Build View
Unit 1A
50 Ferring Street
Ferring
BN12 5JP

Application for Planning Permission for Works or Extension to a Dwelling

Development: Single storey rear extension and hip to gable loft conversion with 2 x dormers following the demolition of existing rear conservatory
Location: 42 Pigeonhouse Lane Rustington BN16 2BE

PIGEONHOUSE LANE

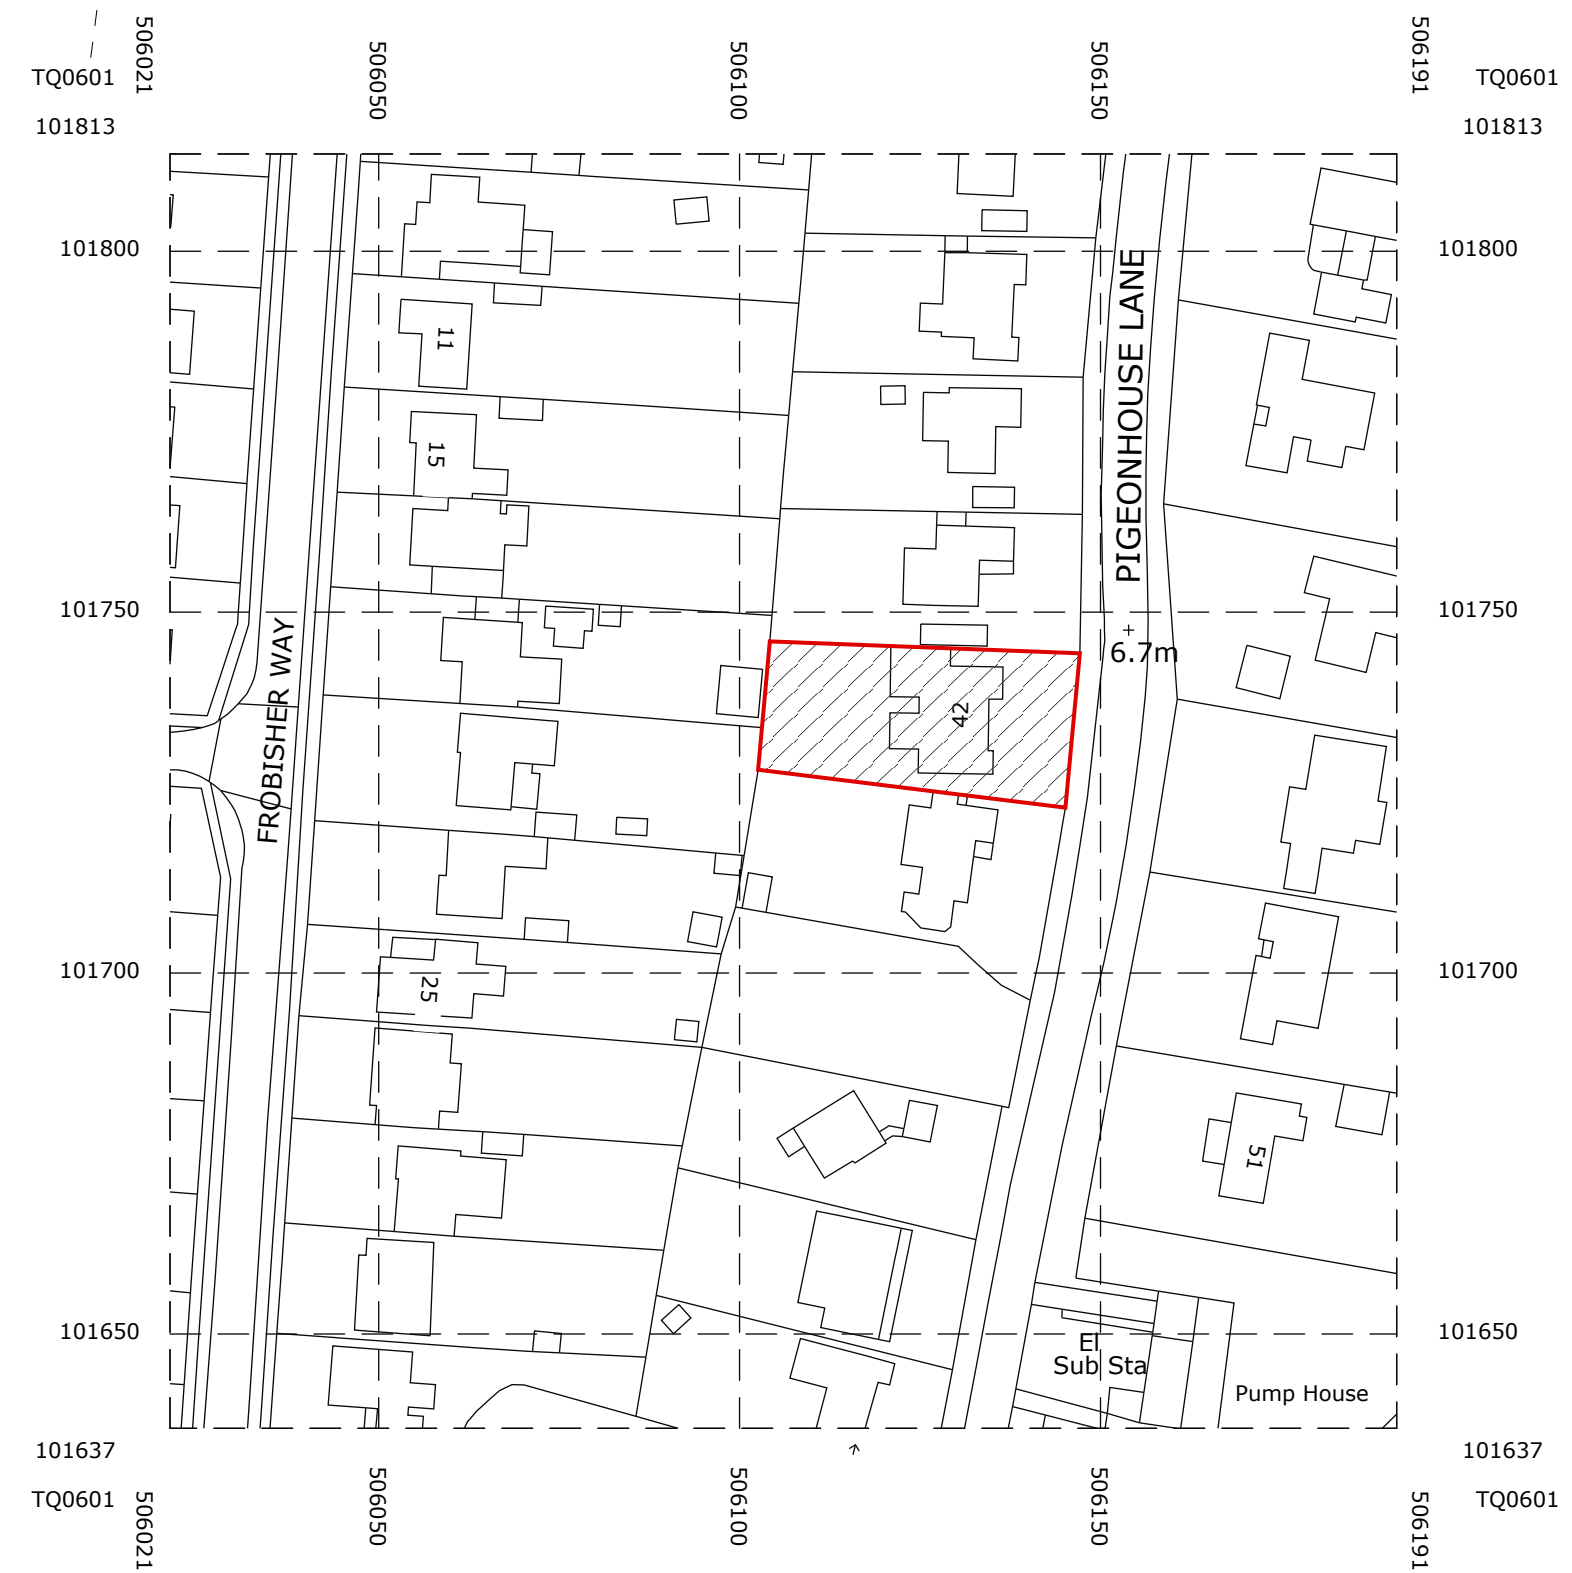
Single storey rear extension and hip to gable loft conversion with 2 x dormers following the demolition of existing rear conservatory
Block Plan

Please add the dimensions from the proposed extension to all site boundaries on the block plan. The dimensions to the side boundaries are missing. Please amend.
